Your Ref: OWPC18939
Our Ref: BR/229/17/PL 11-08-2017
Please ask for:
Mr S Davis

Erection of 3 No. dwellings, 1 No. detached garage, parking & alterations to existing access & driveway (resubmission following BR/200/16/PL).

Land to rear of 41 - 47 Pevensey Road Bognor Regis

Thank you for your internet representation made on 20th June 2018 which has been recorded as '**an objection**' with the comments as follows:

Proposed Elevations

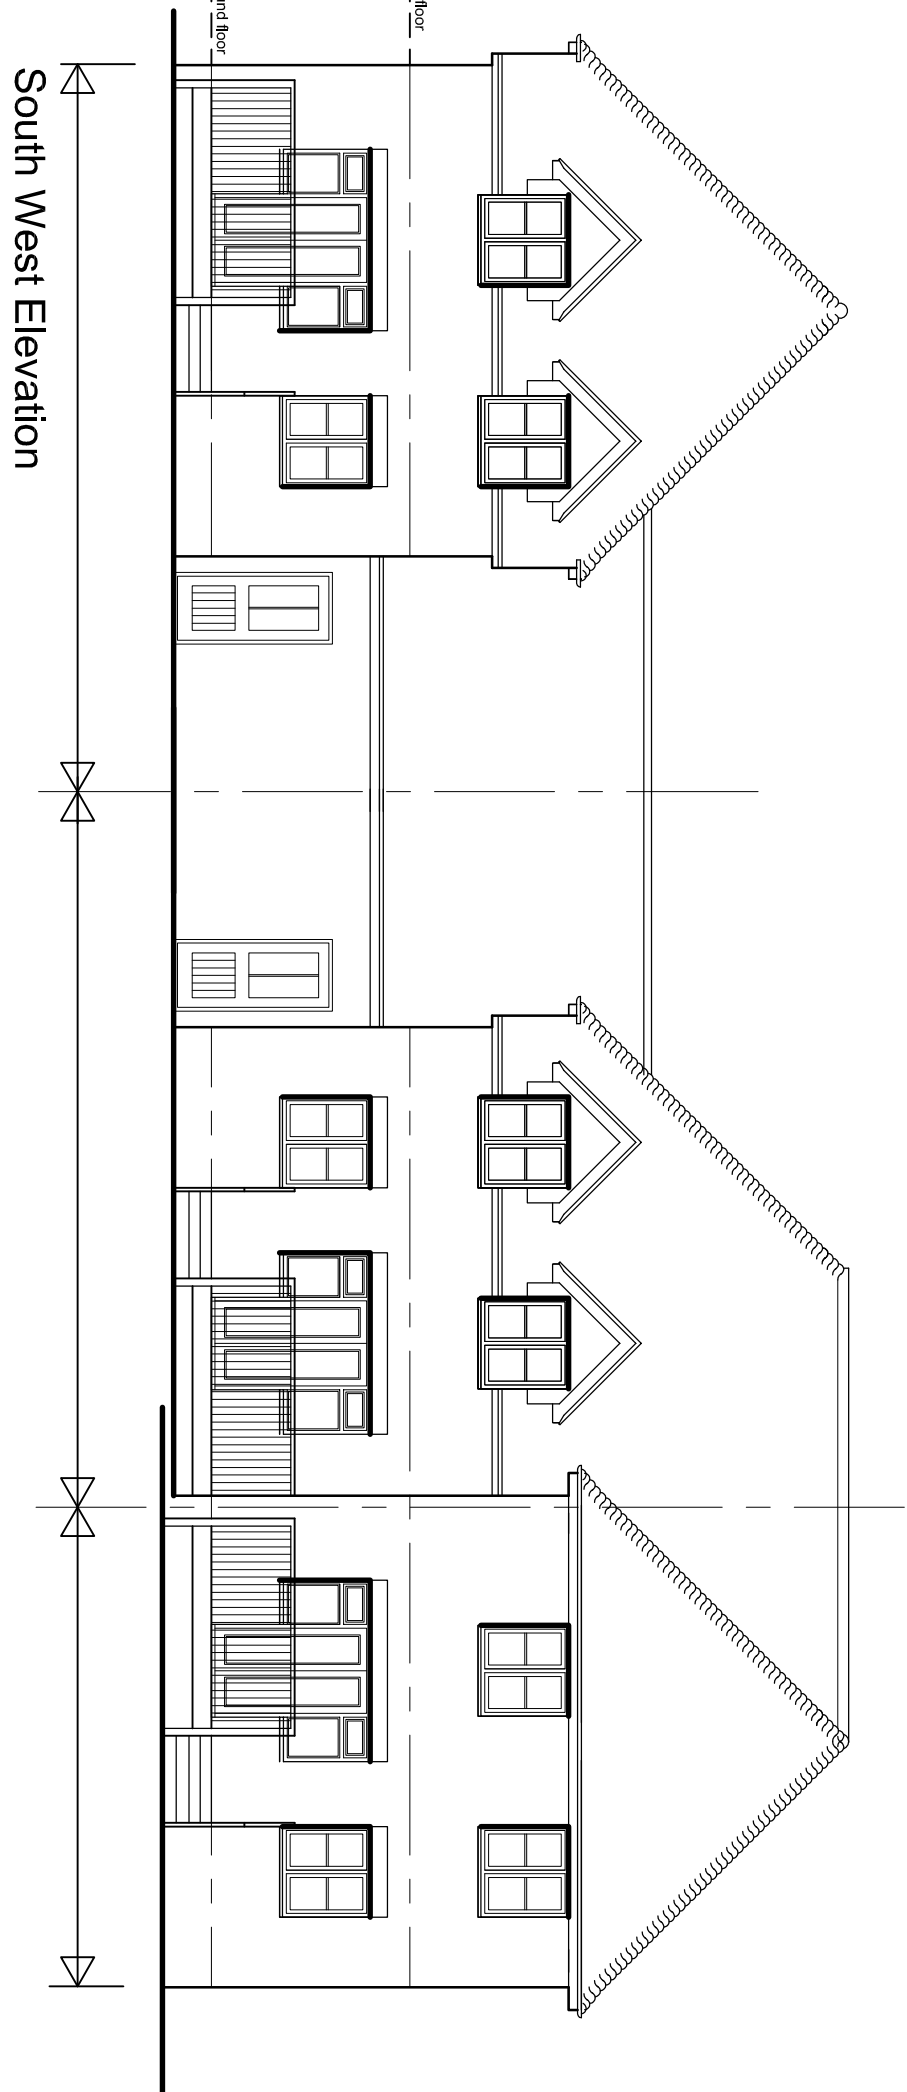
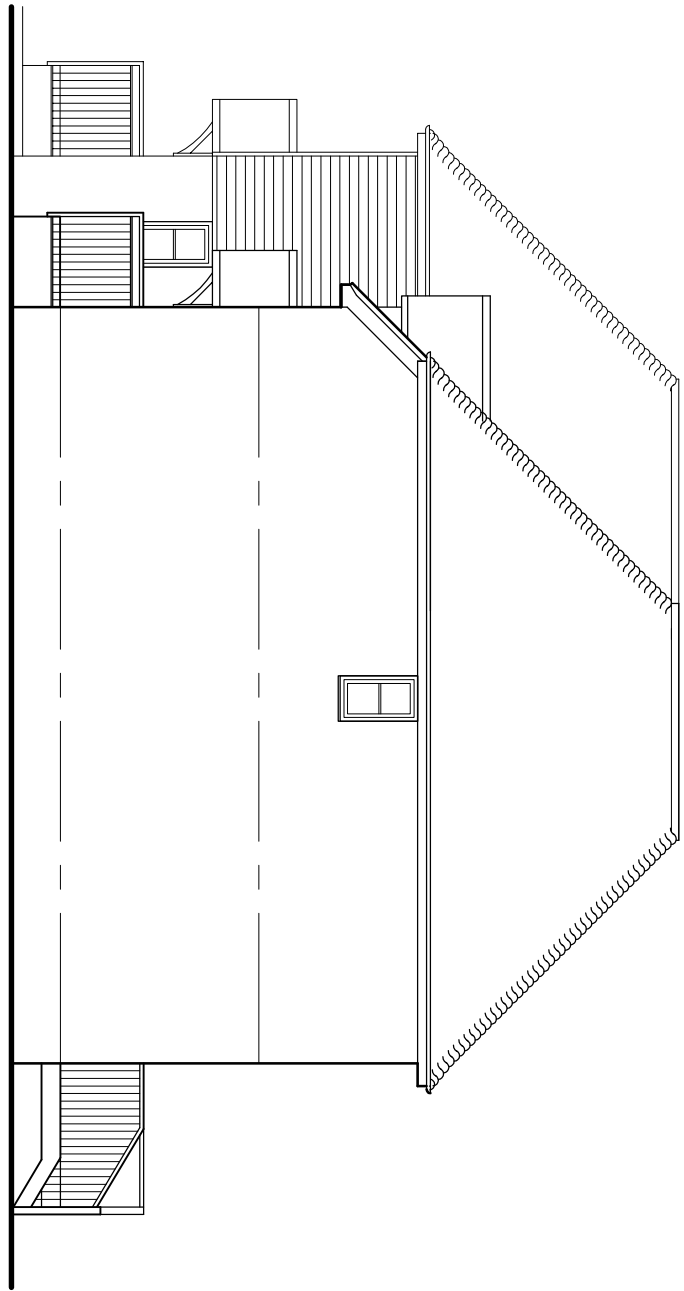
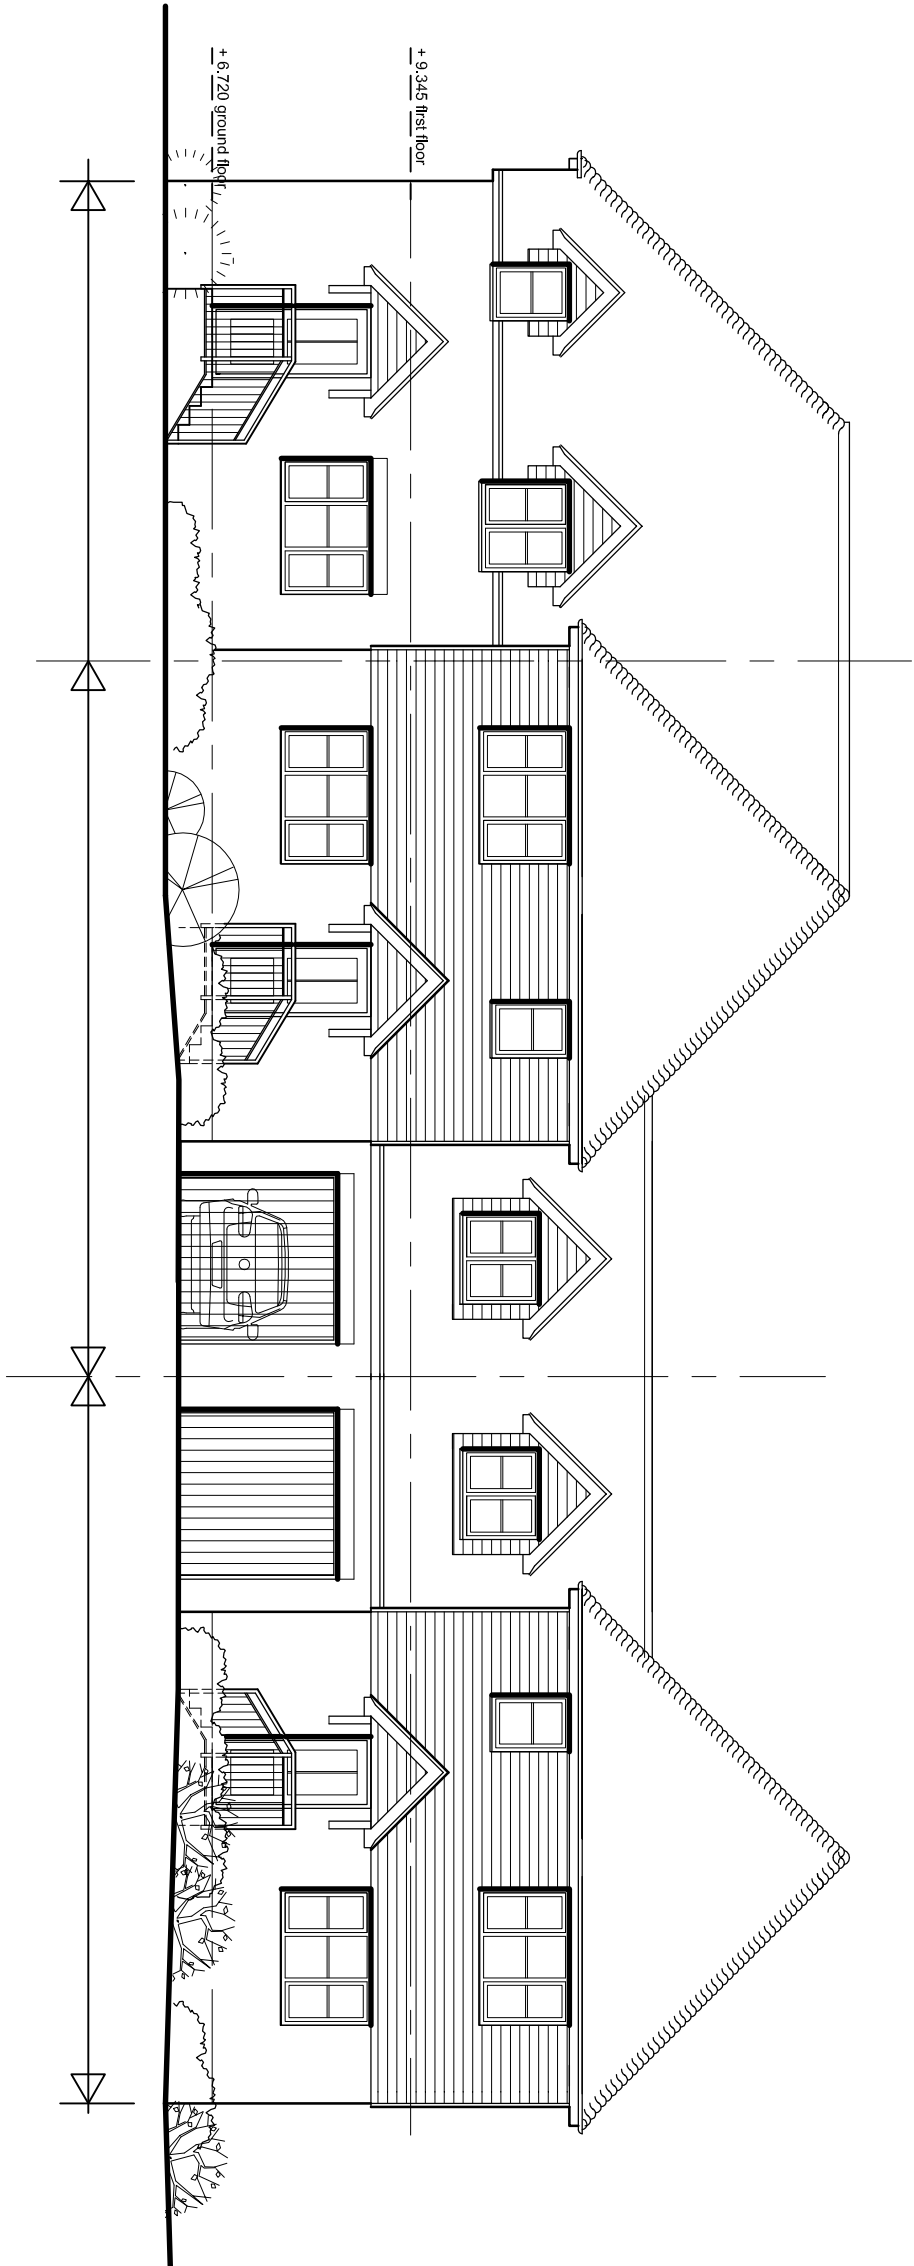
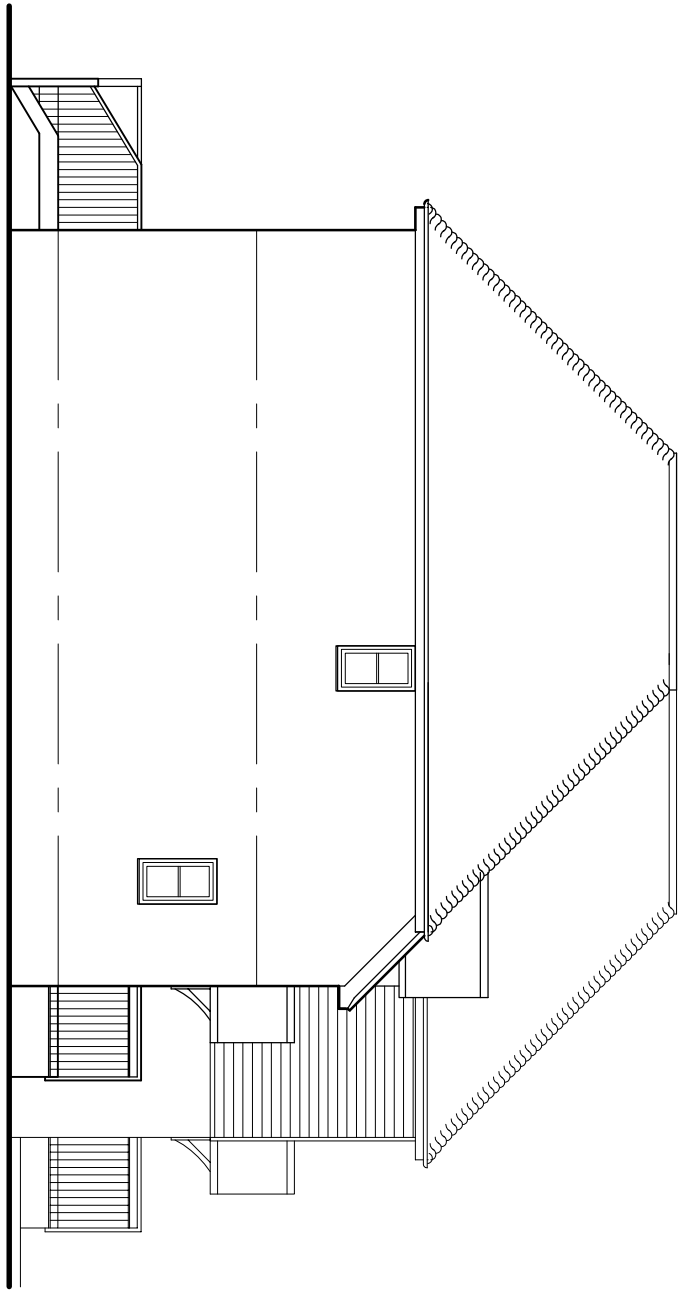
4. The new houses would be taller than ours so we would feel overlooked in Arun Road.

DRAWING TITLE	
Block & Location Plans and Site Section	
DATE	SCALE
Feb 18	1:200 @ A1
JOB NO.	DRAWING NO.
1615	2.13
	CHECKED BY
	REVISION
	DRAWN BY
	GIM

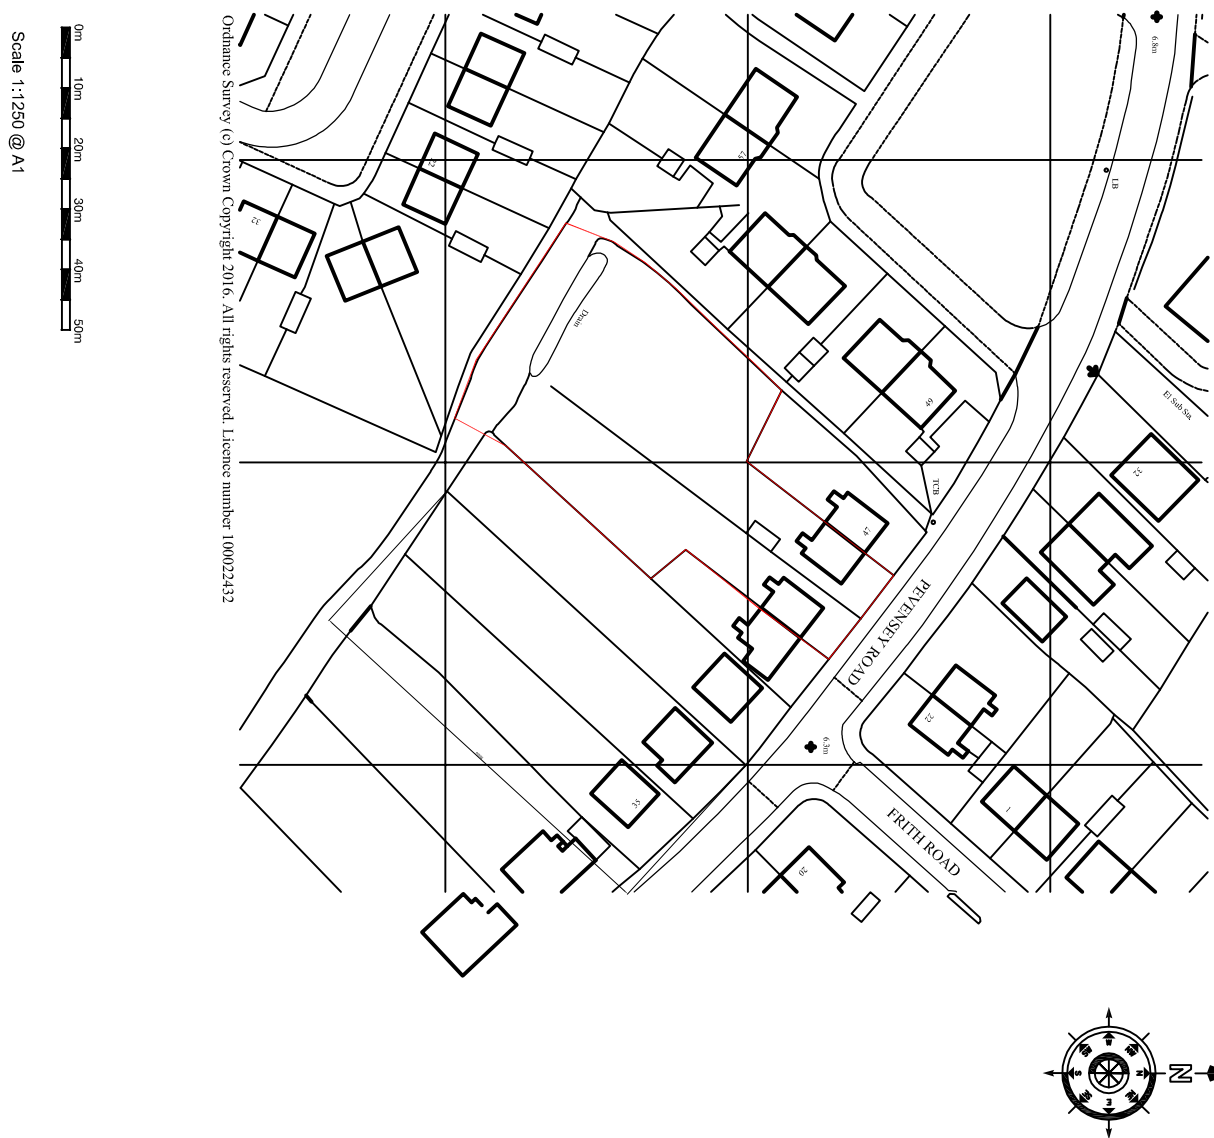
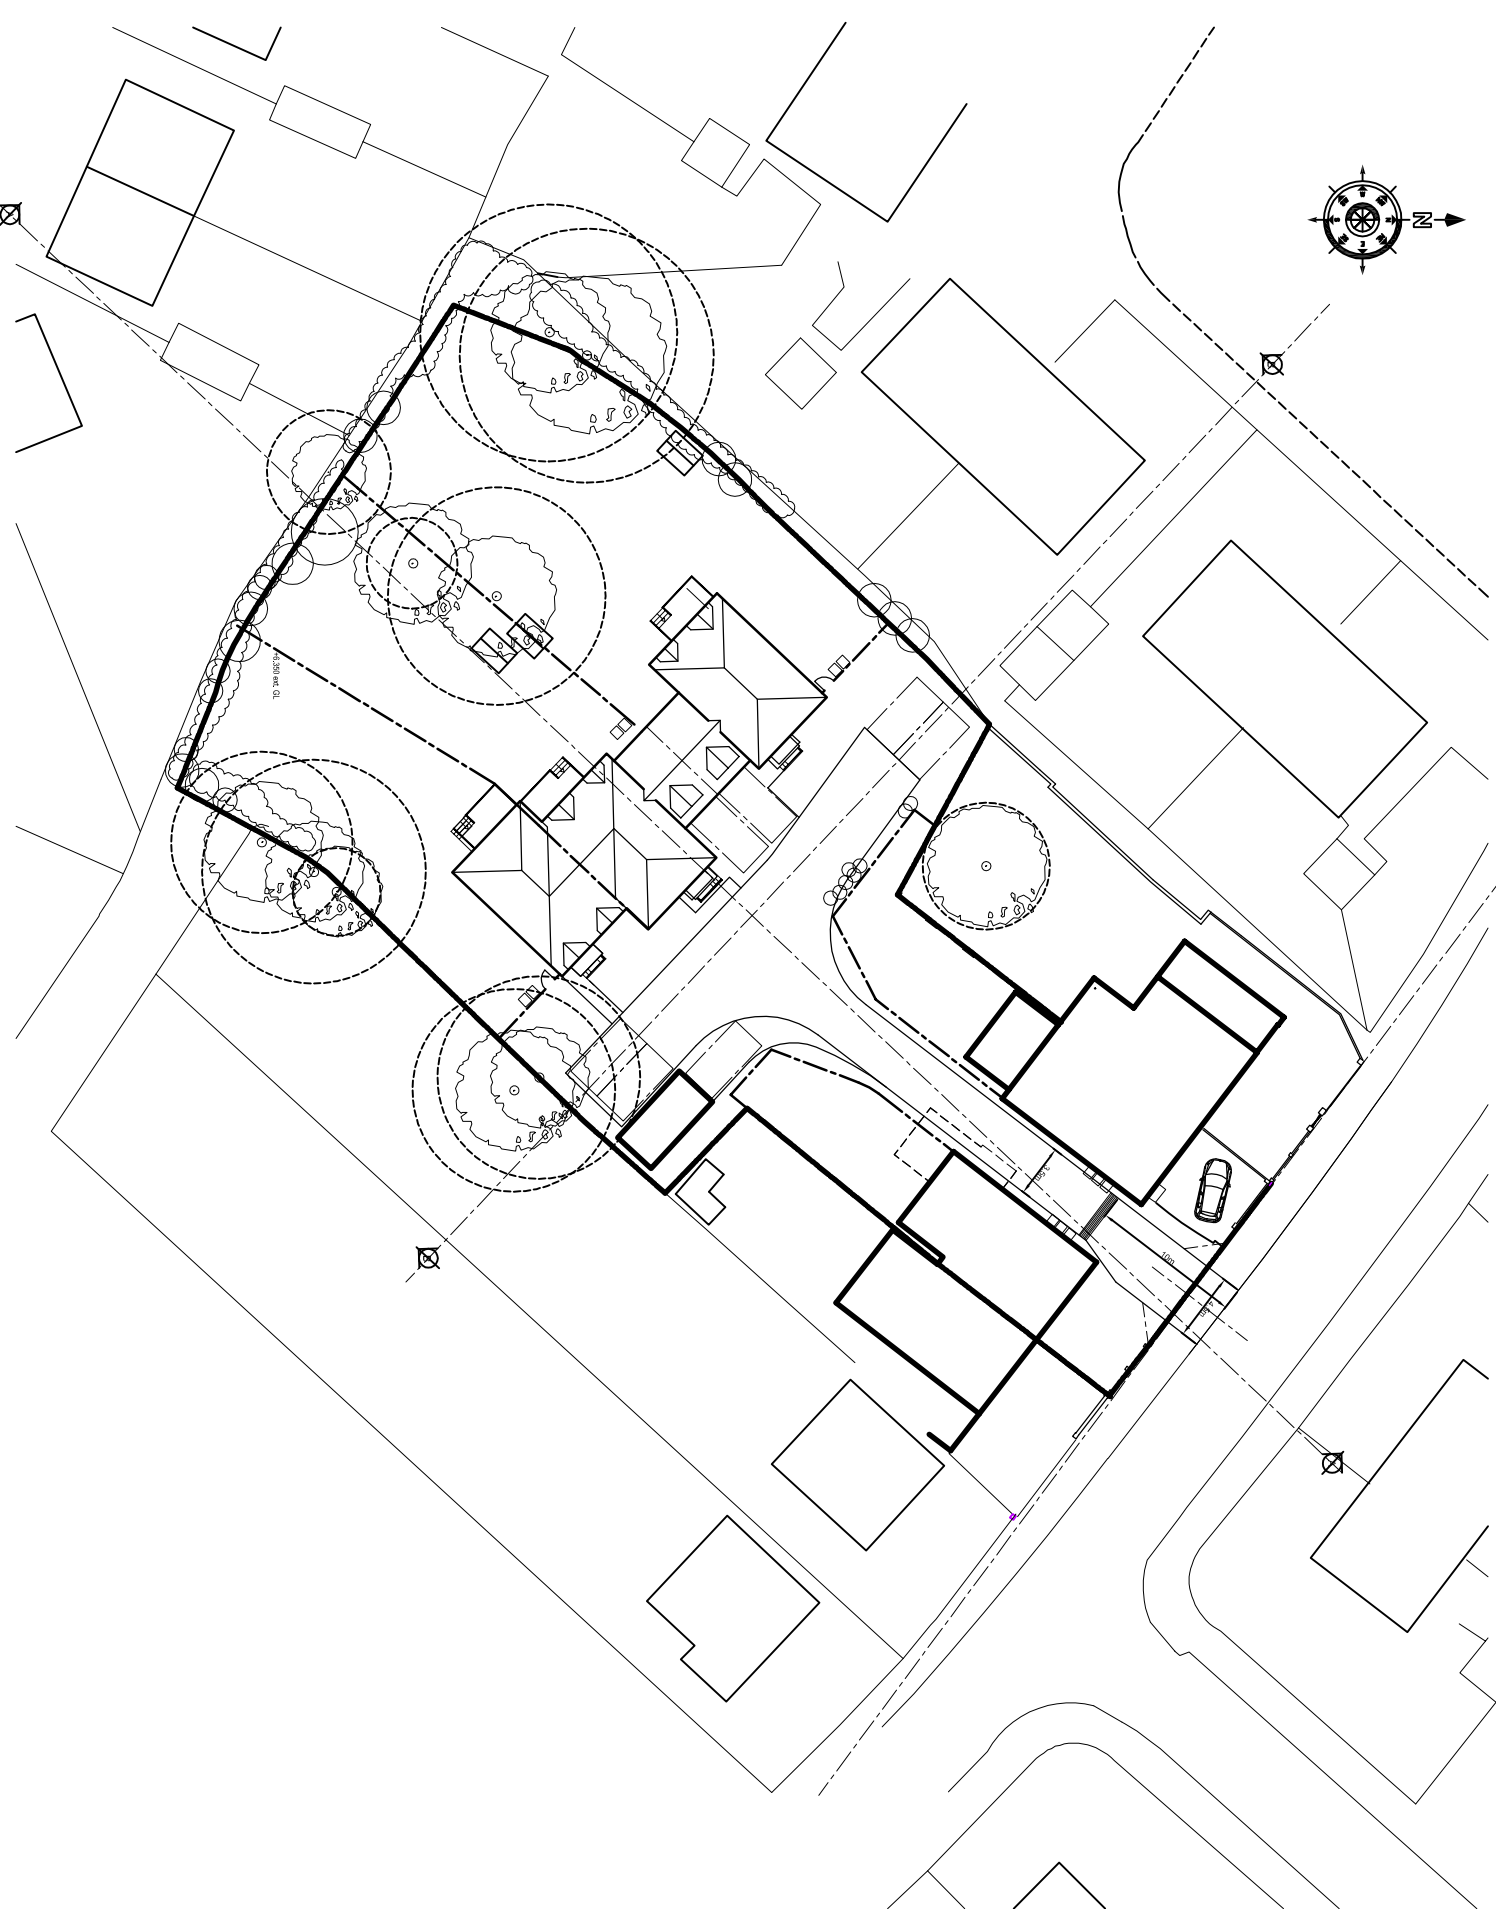
Plot 3 and the detached garage and parking spaces are far too close to the other two large protected trees and the roots will be damaged and the trees will either die or have to be removed this is not acceptable or fair as these two trees are in Mr Borgs garden in number 39, (just behind the boundary fence) he wants to save the trees he doesn't want to lose them!

3. The land levels have not been taken on purpose to hide the fact the land levels are so different in gardens 43 and 45, the garden directly behind me (45) has not been maintained for years, the undergrowth is so bad behind my fence it's damaged my fence and decking it's so wild and overgrown.

Why doesn't someone from planning come and see the two gardens to see for themselves the differences in land levels and the close proximity to the protected trees as many people have repeatedly objected to the same thing.
